Re: Rand-Milestone Short Plat  
7621 SE 22<sup>nd</sup> Street  
Mercer Island, Washington  
CAO 21-004

This letter provides geotechnical review comments for the above-referenced project. The proposed short plat was reviewed for compliance with Mercer Island City Codes (MICC):

MILESTONE PRELIMINARY SHORT PLAT

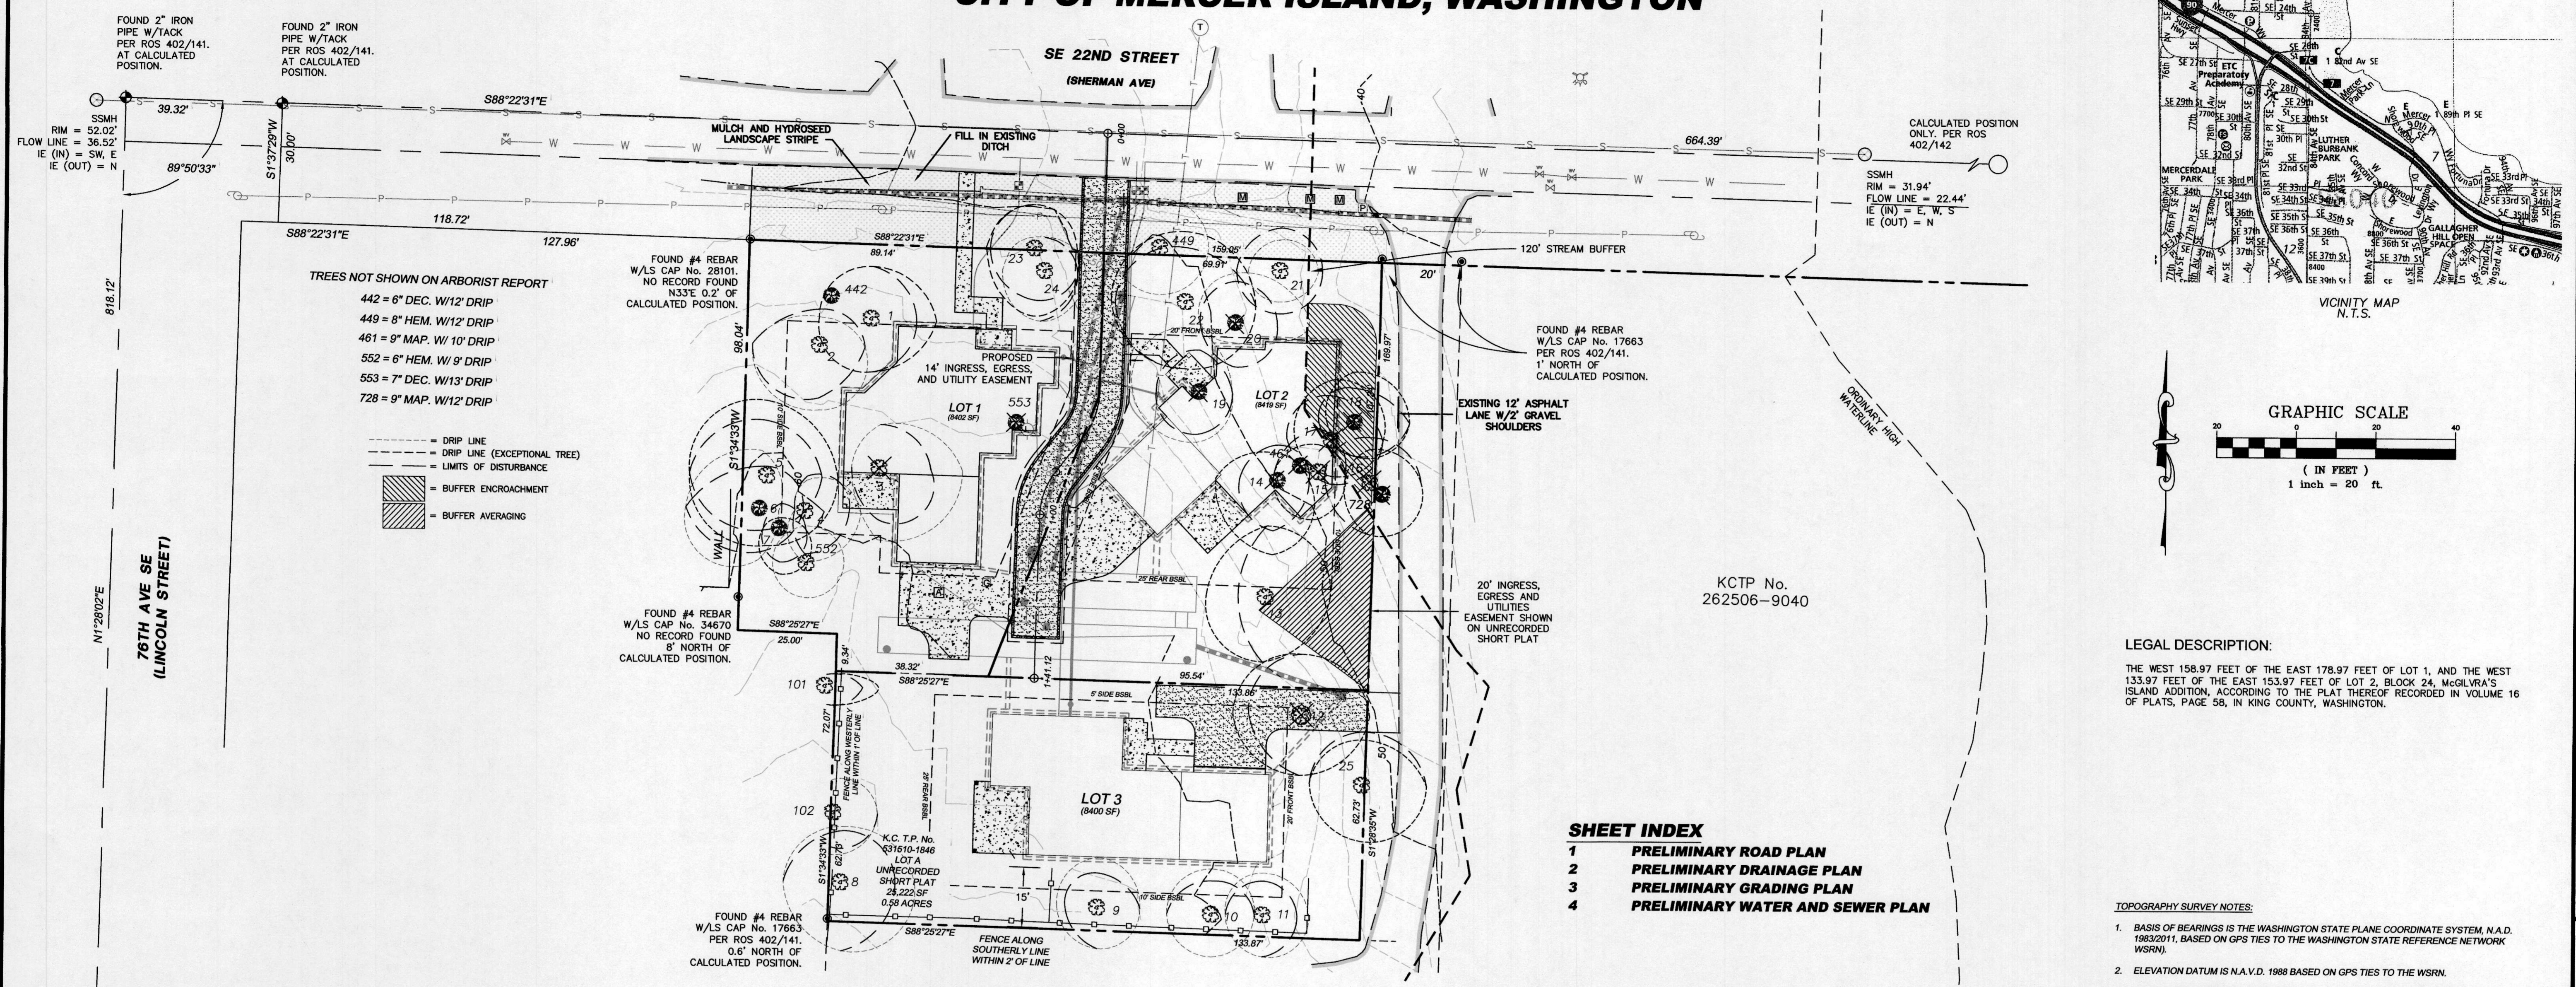
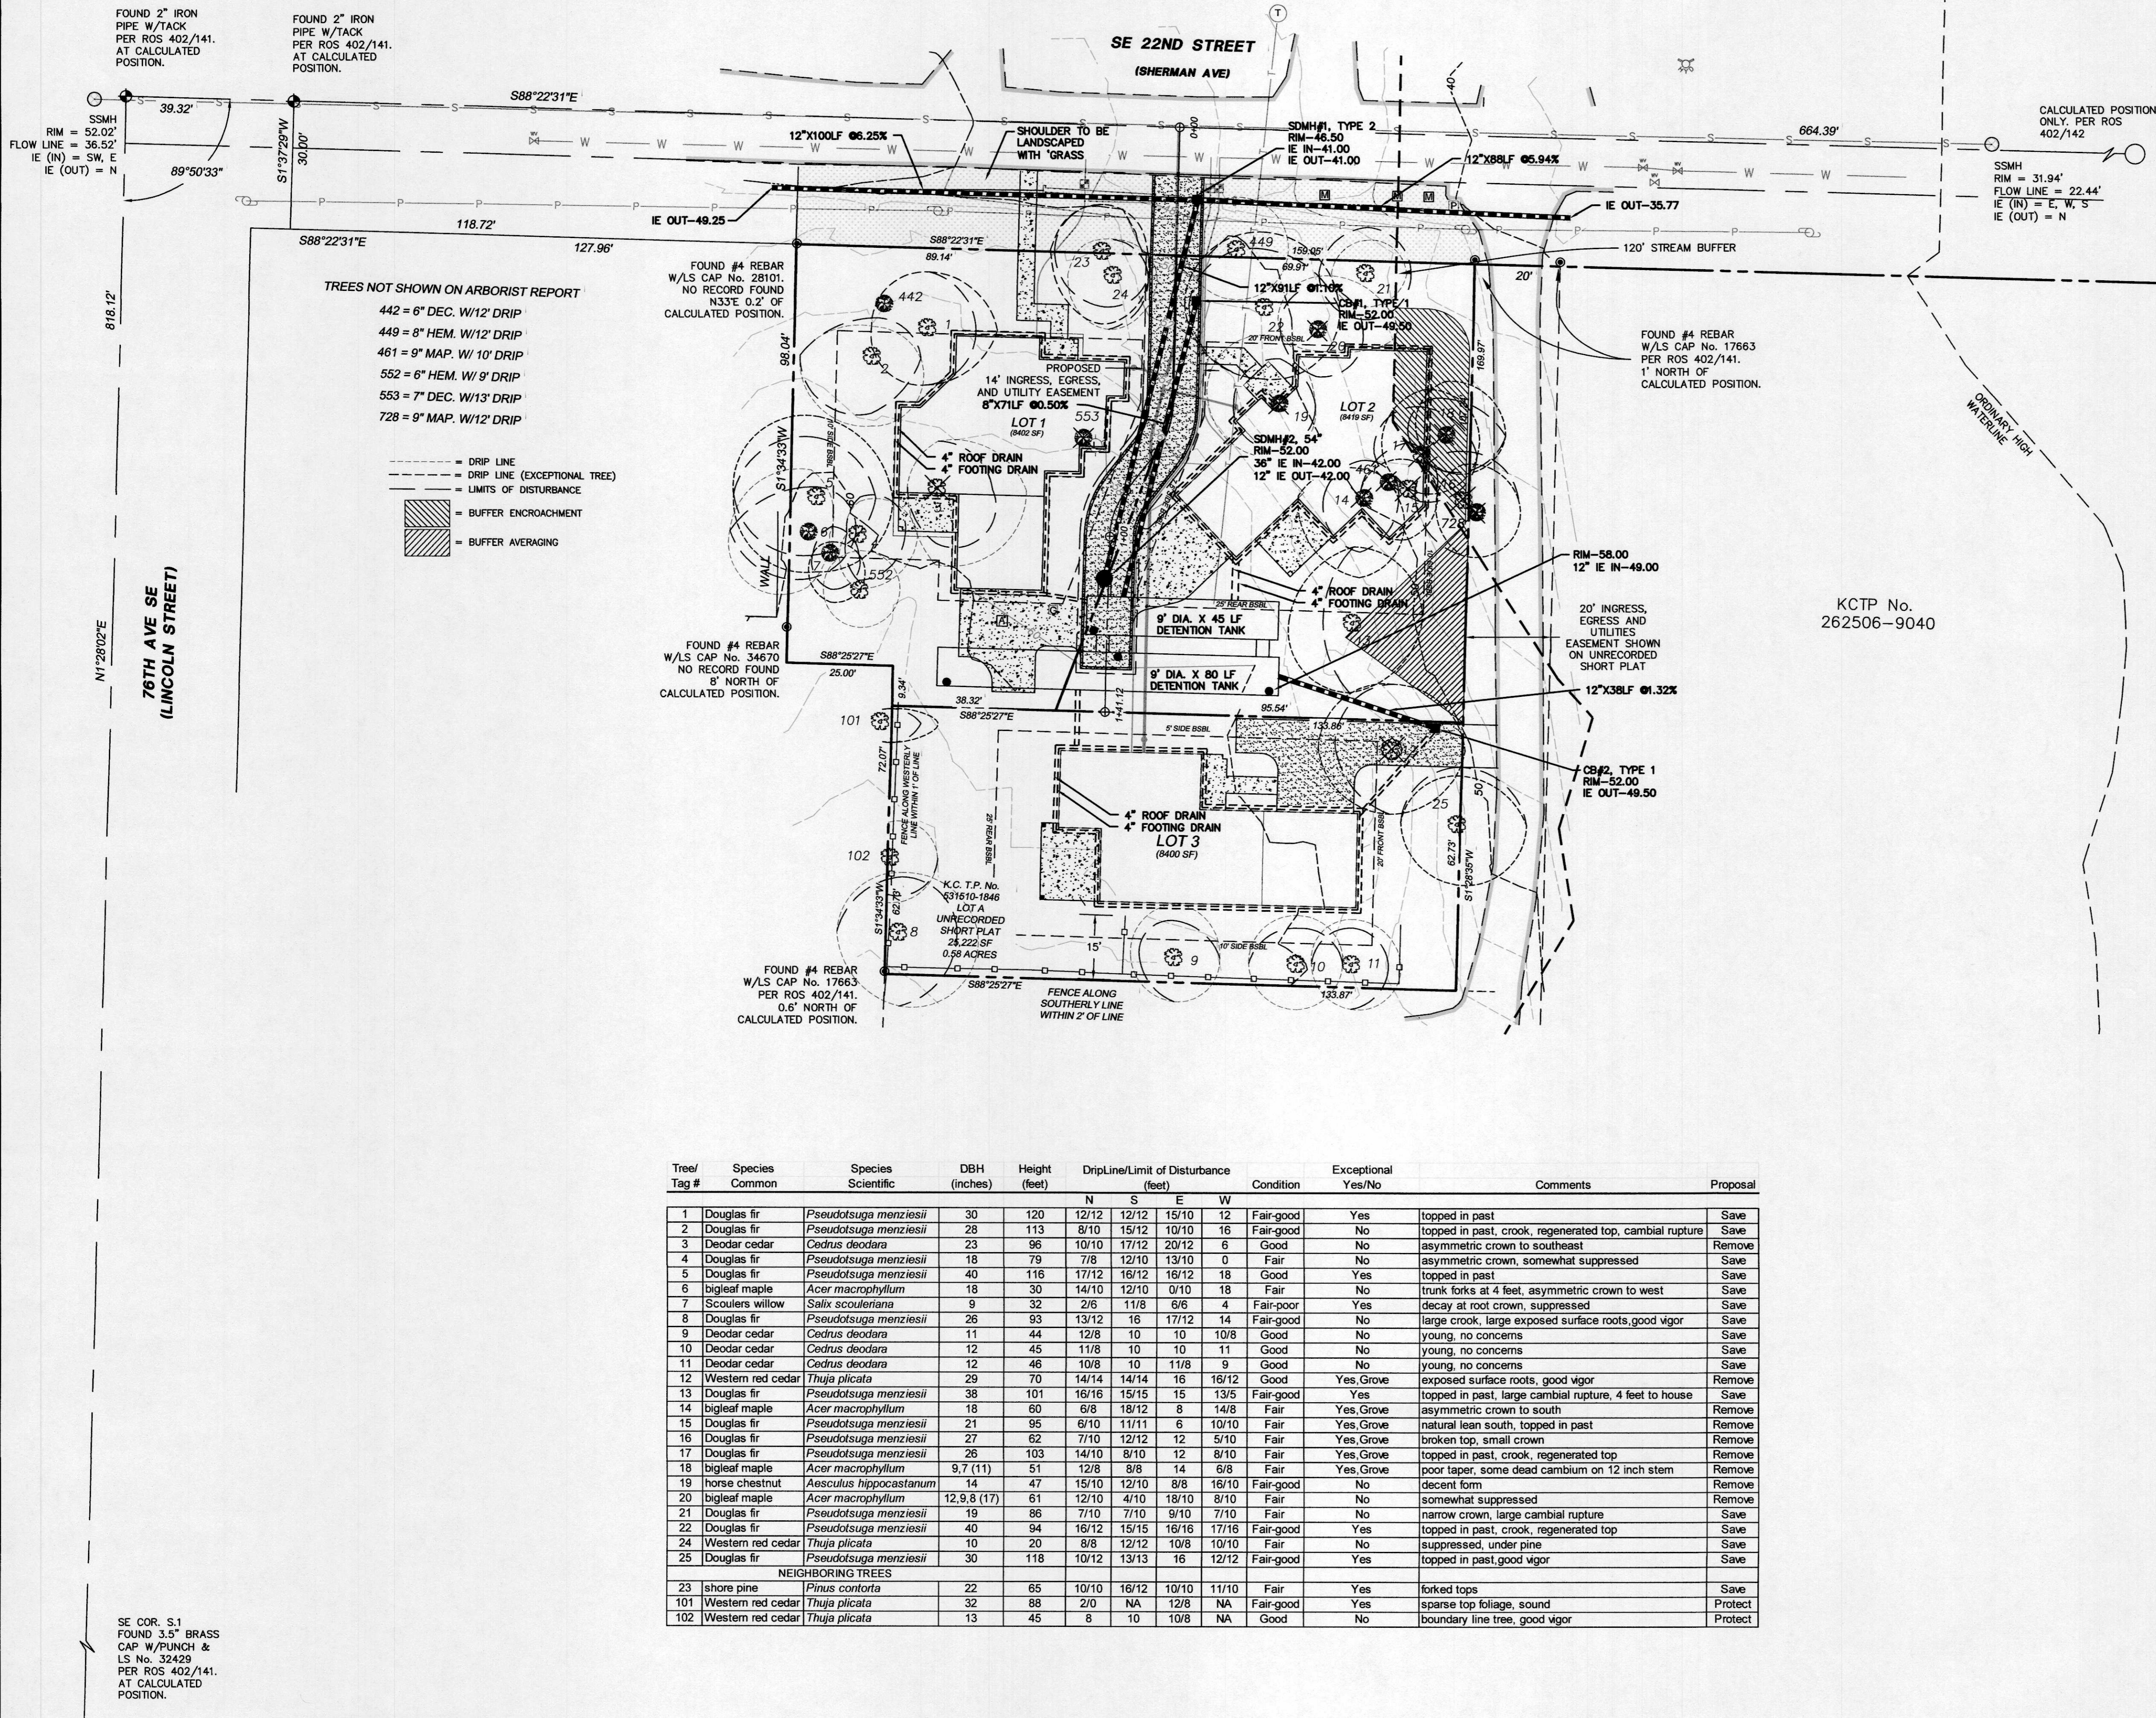
It appears that Lot 2 is located over the sloped portion (also designated landslide hazard) of the site. No final grading is provided in this area.

**Comment 4:** This code section (MICC 19.09.090) cannot be met without meeting code section MICC19.07.160. Provide proposed final grades for the proposed lots. Provide information regarding proposed building excavation, e.g., will basement levels be involved? Provide an anticipated basement level elevation or finished floor elevations for at-grade structures for the proposed lots.

Adequate grading information should be provided for Lot 2 so that the geotechnical engineer can assess potential slope stability impacts and provide design mitigation recommendations.
